EPC STORMWATER REVIEW COMMENTS  
IN ORANGE BOXES WITH BLACK TEXT

# 2023 Financial Assurance Estimate Form (with pre-plat construction)

PROJECT INFORMATION			
FAWWA Water Treatment Plant	3/27/2023	TBD	PPR2314
Project Name	Date	PCD File No.

FALCON AREA WATER AND WASTEWATER AUTHORITY - WATER TREATMENT PLANT
GRADING AND EROSION CONTROL PLAN
DESIGNED BY JDP SCALE DATE 3/28/23
DRAWN BY JDP (H) 1"= 30' SHEET 2 OF 4
CHECKED BY KRC (V) 1"= N/A JOB NO. 1307.00

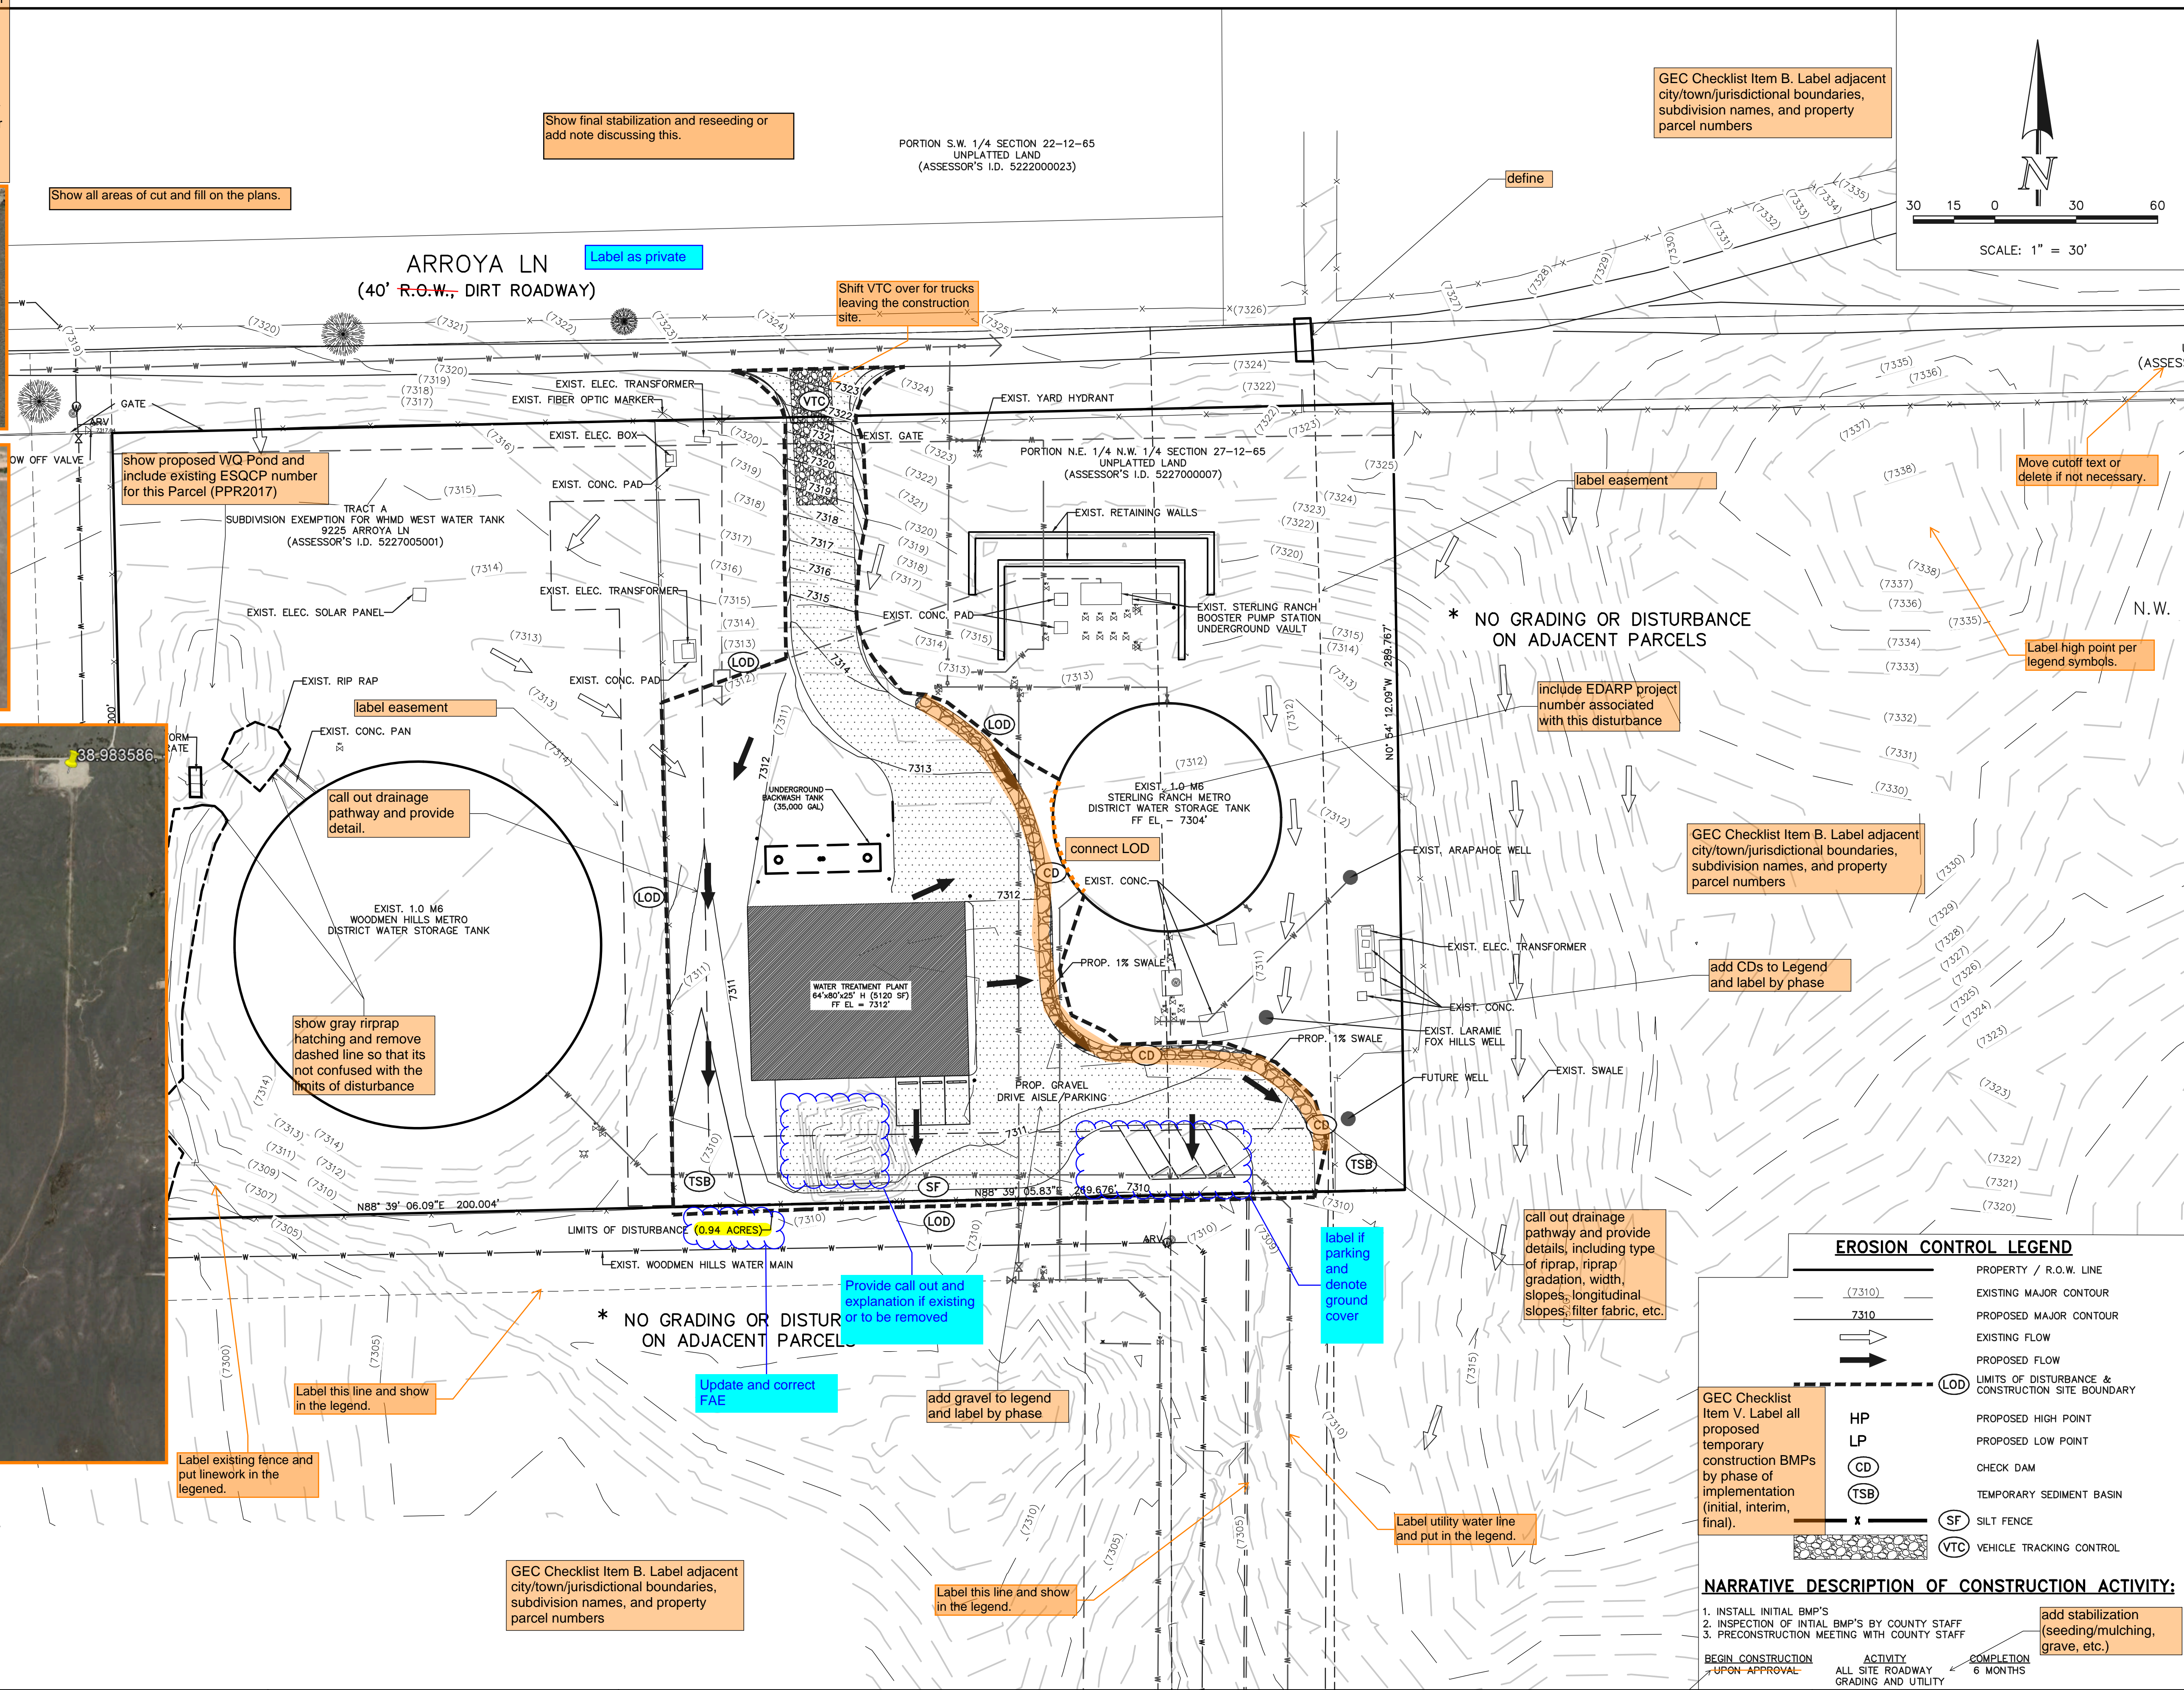
Update values to cover all disturbed area which exceeds 1ac
